March 16, 2001

RE: Grading and Drainage Plan for National Electric Supply (G15-D59) (PWDN 10018)
Dated January 25, 2001

These are our comments for the National Electric Grading and Drainage Plan, PWDN #10018.

SHEET # 1

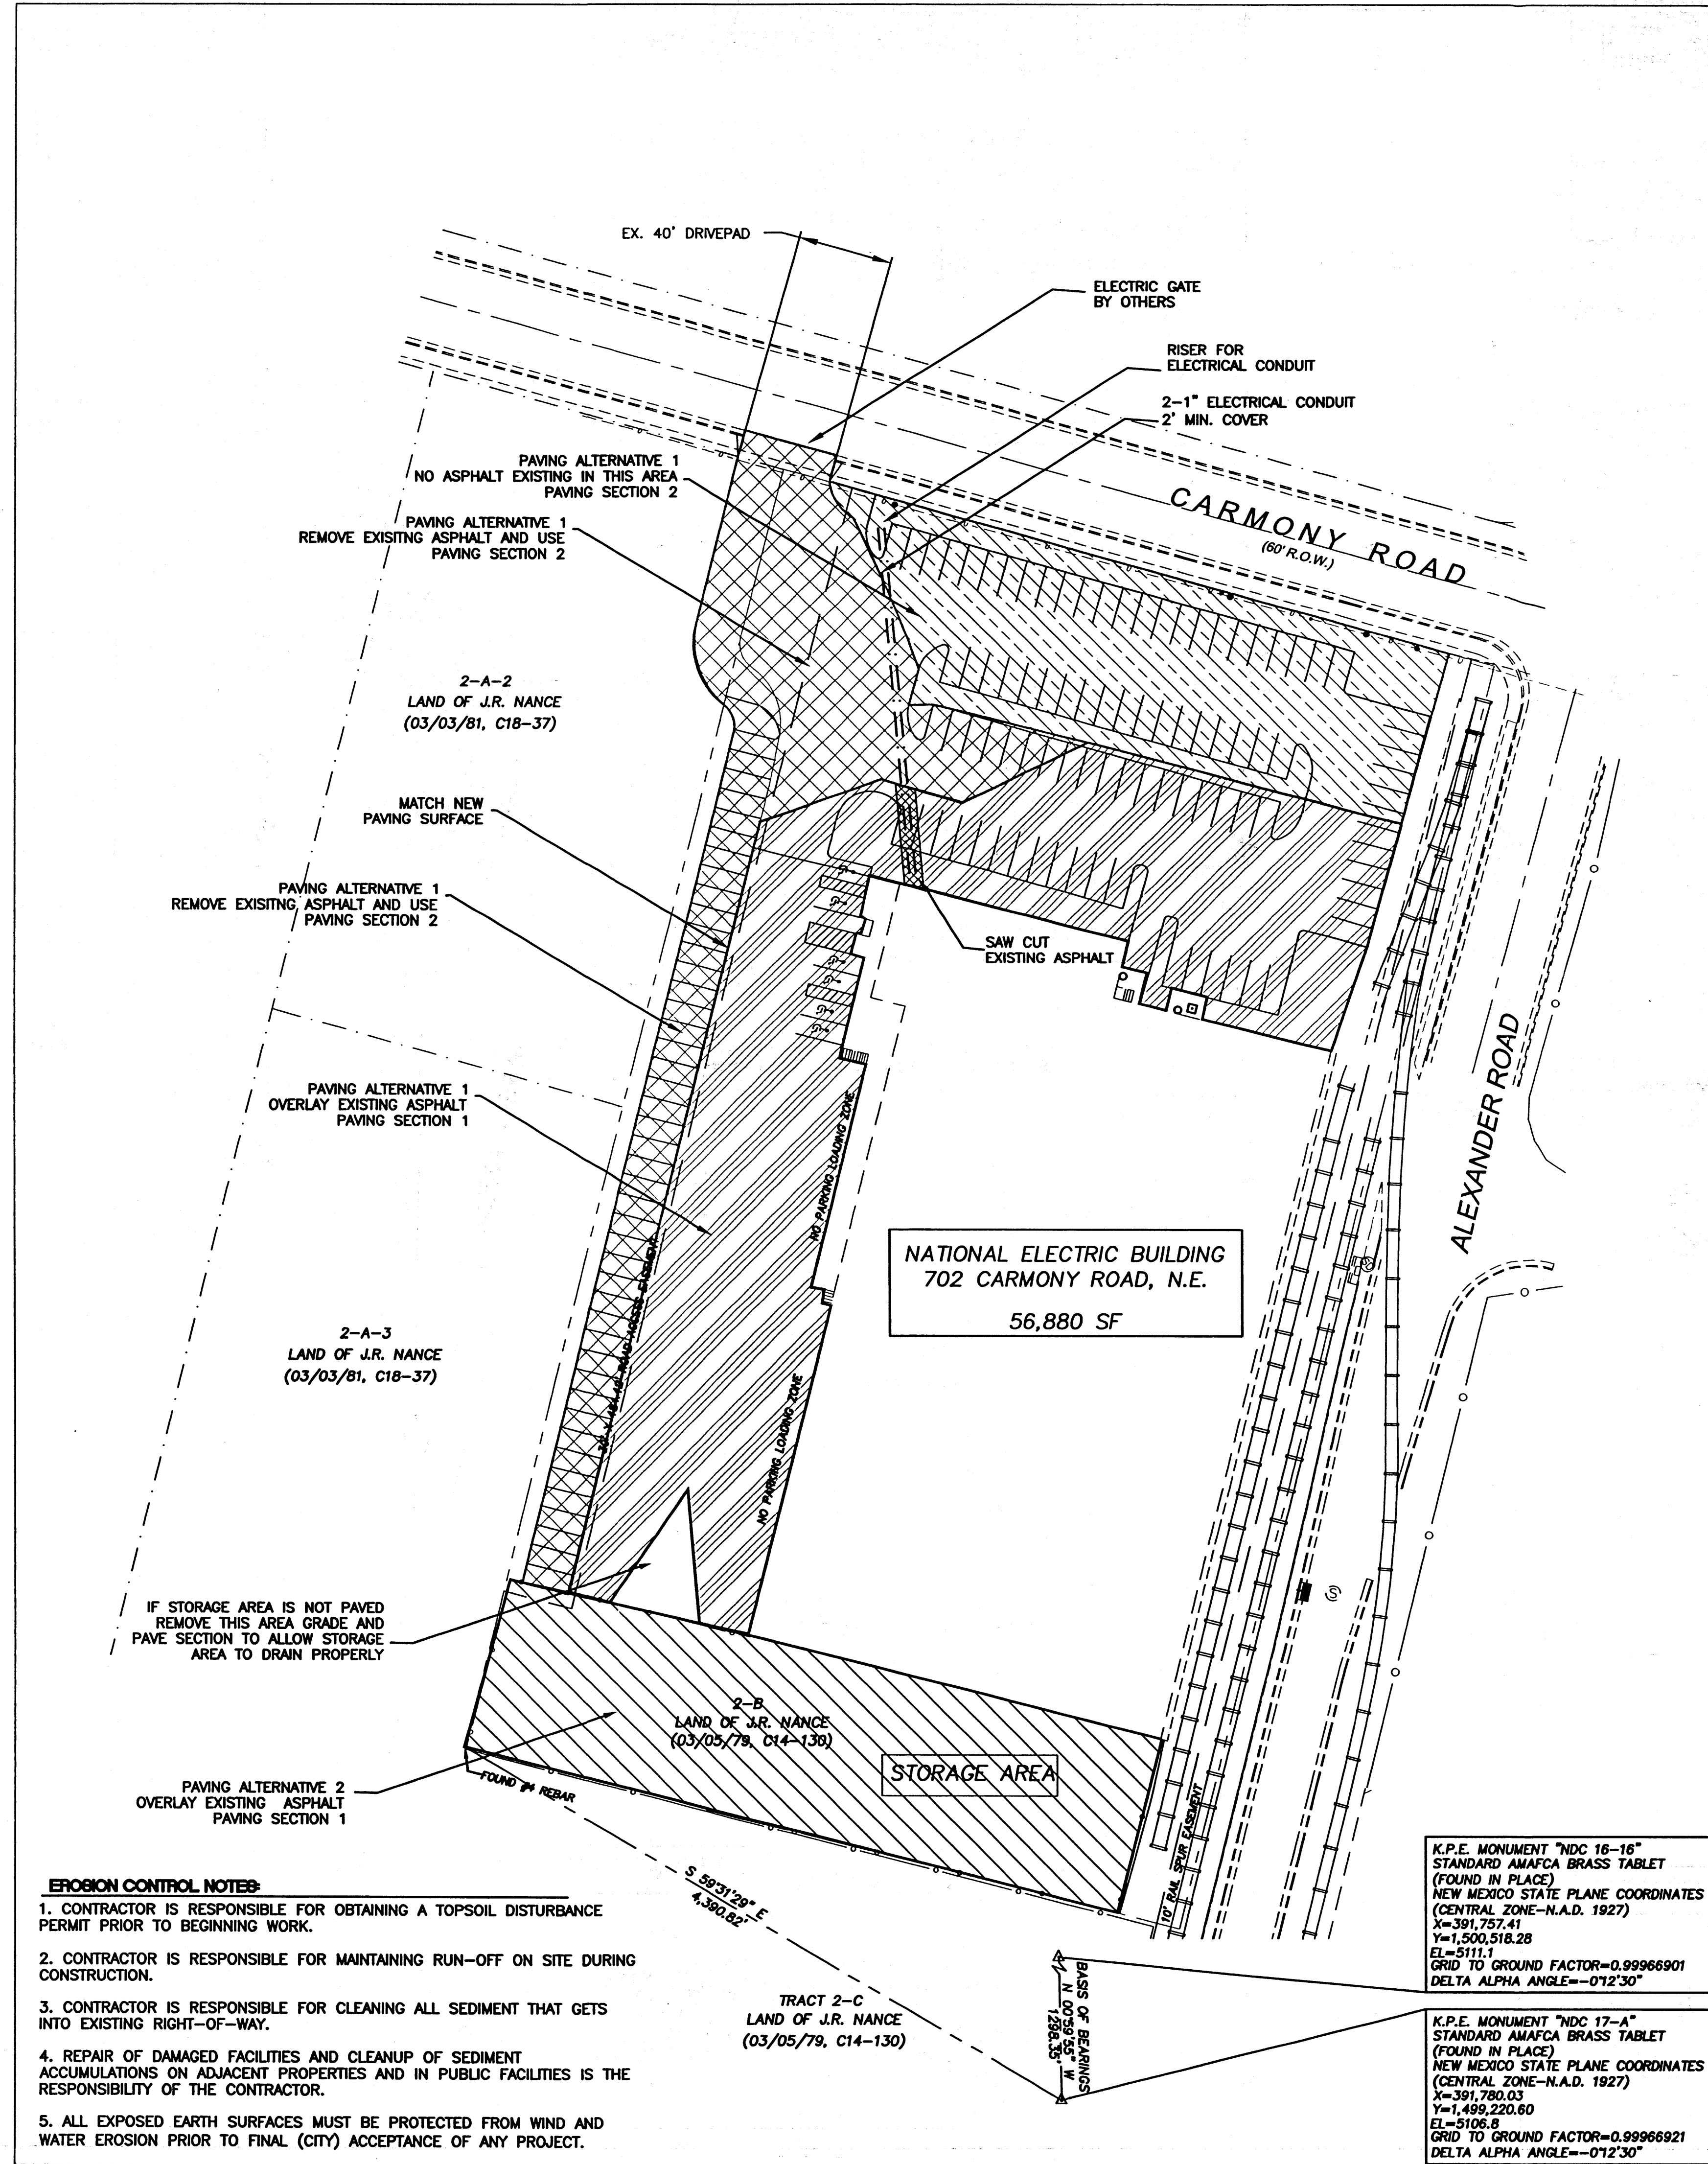
1. Development of this property must conform to this plan. Any proposed changes will require a revision to the plan prior to initiating the proposed change.
2. Inspection required, applicant required to obtain permits from Bernalillo County Public Works Division (Phone 848-1520).
3. The old pond must be filled in with suitable material, and all garbage must be removed.

The old pond must be filled in with suitable material, and all garbage must be removed.
